Arun District Council
Arun Civic Centre
Maltravers Road
Littlehampton
West Sussex BN17 5LF
Planning General Enquiries
Tel: (01903) 737756 Fax: (01903) 730442
Dx: 57406 Littlehampton
Minicom: 01903 732765
e-mail: planning@arun.gov.uk
website: www.arun.gov.uk/planning

Town & Country Planning Act 1990 (as amended)
Town and Country Planning (Development Management Procedure) (England) Order 2015
Approval of details reserved by condition imposed under BN/53/18/HH relating to conditions 3-
surface water drainage & 4-discharge of any flows to watercourses.
37 Hill Lane Barnham, Bognor Regis,

Arun District Council have decided to **REFUSE details reserved by condition for the following reasons:**

Project:	37 Hill Lane. Barnham	Date:	Mar 2019	Made by:	KS	Sheet No.	1
CALCULATION SHEET		Job No.	1870	Chkd:	-	Rev.	0

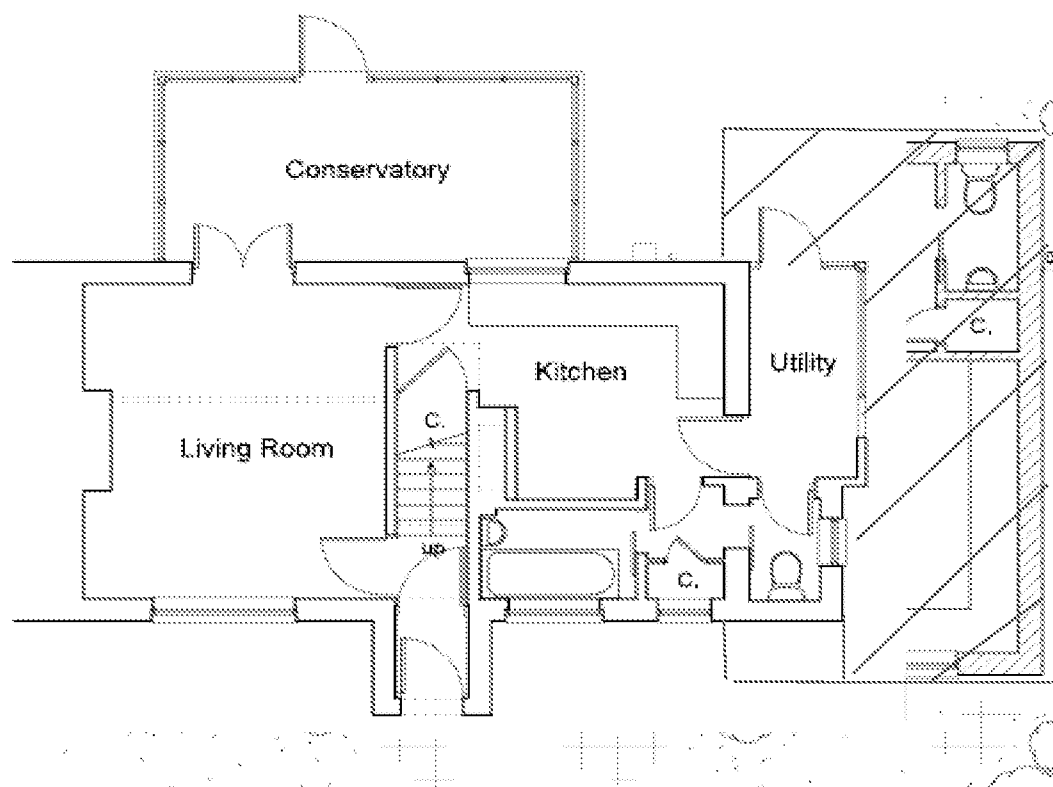
The previously supplied design stated that infiltration rates of 1×10^{-6} to $3.5 \times 10^{-7} \text{ ms}^{-1}$ were found. Yet the revised design states that an infiltration rate of $4.17 \times 10^{-4} \text{ ms}^{-1}$ was found. It is unclear how such a vast improvement in infiltration rates was found. Knowing the area well I do not believe infiltration rates will be this good, the initial rates found are far more in keeping

with the underlying strata and surrounding results.

Can the applicant please provide further information on the testing completed. I.e. photos and record sheets. A location plan showing the location of groundwater monitoring and infiltration testing must be provided.
